From: Jeff Tarling
To: Jean Fraser
CC: David Margolis-Pineo
Date: 5/15/2015 10:48 AM
Subject: Congress Street Jewish Center

I have reviewed the proposed landscape plan for the Jewish Neighborhood Center on Congress Street and offer the following recommendations:

-  CANOPY TREE
-  ORNAMENTAL TREE
-  EVERGREEN TREE
-  TURF
-  SHRUBS / ORNAMENTAL GRASSES / GROUNDCOVER
-  RAIN GARDEN PLANTINGS

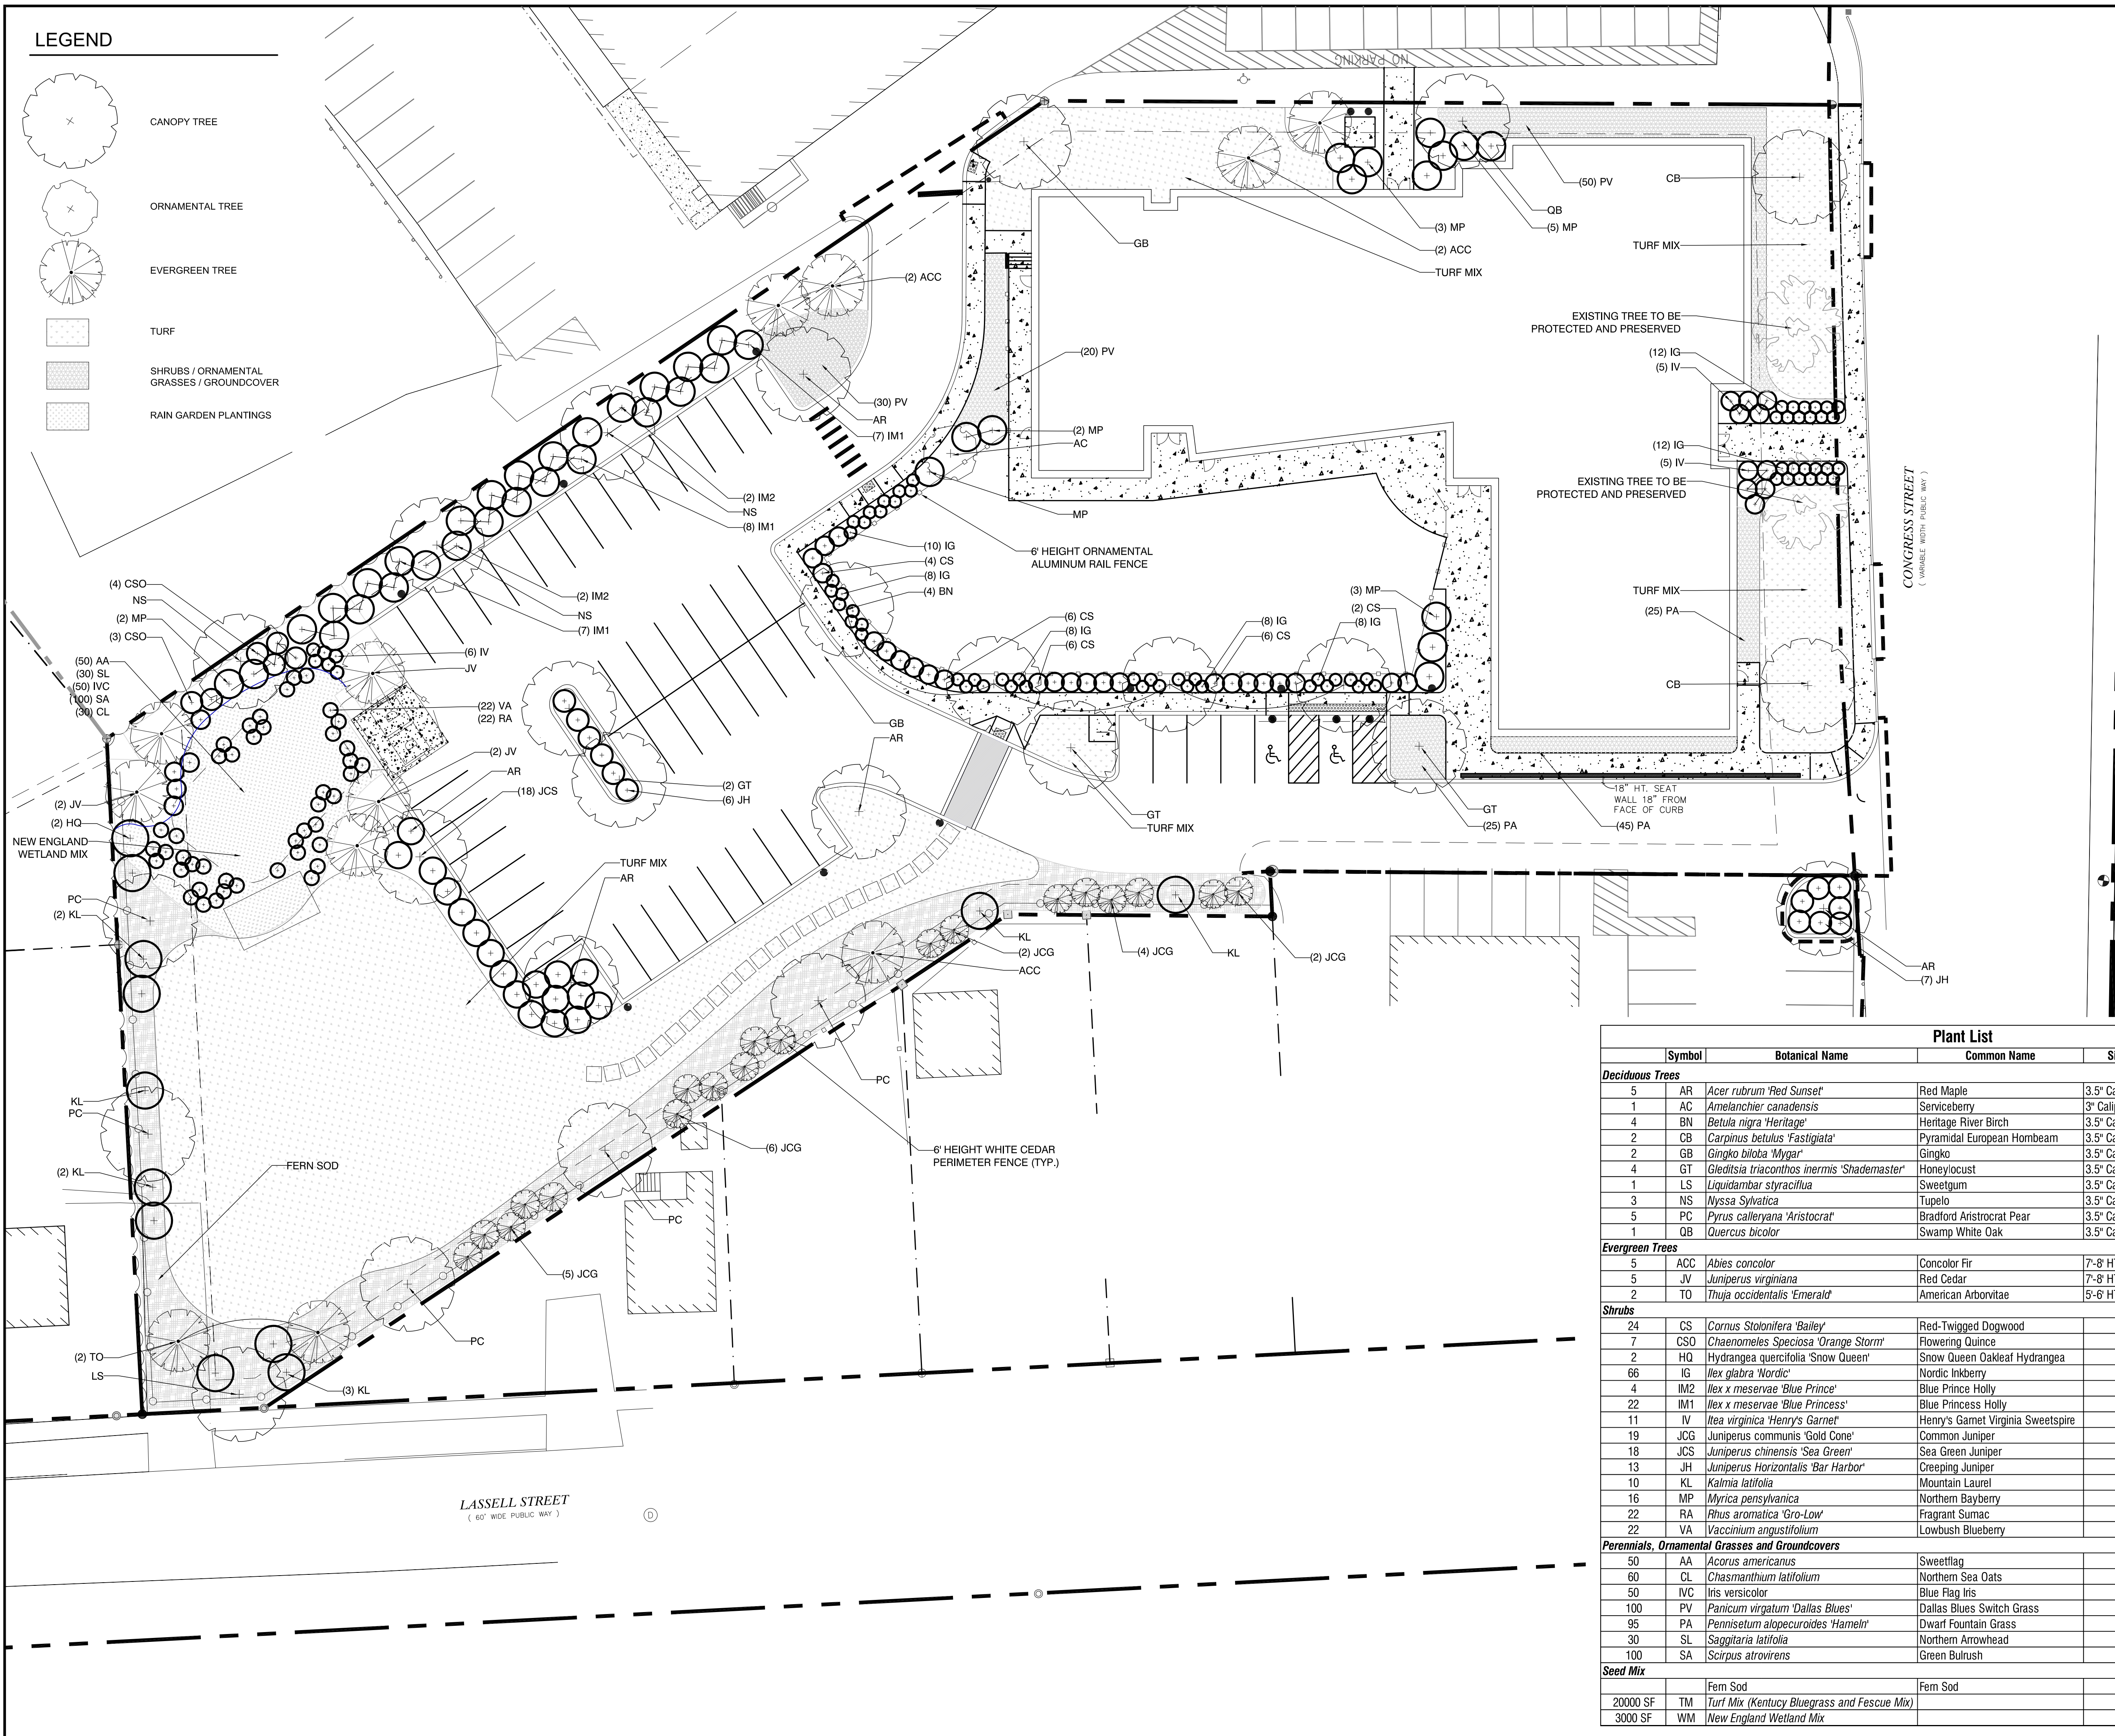
Looking at the back property line and the graphic showing a proposed fence, which is recommended, wanted to request a fence spec. My first thought is that the fence should be wooden 6' in height or something equal.

The project removes several mature trees on the side entranceway and does not appear to replace them. Looking at the space it appears to be wide enough that several, 3 - 4 small trees such as Magnolia, Dogwood or Cherry could be successfully planted back in this location. We have also seen good use of the several upright Oak varieties that stay very narrow but with height that could help replace the lost trees, see: <http://www.jfschmidt.com/pdfs/regalprinceoak.pdf> Improving this space should be a priority. Also noted that a small center landscaped island near the entranceway could be used to improve or define the drive into the site.

Overall the rest of the landscape plan appears to meet our landscape & tree standards with recommended varieties and plant sizes.
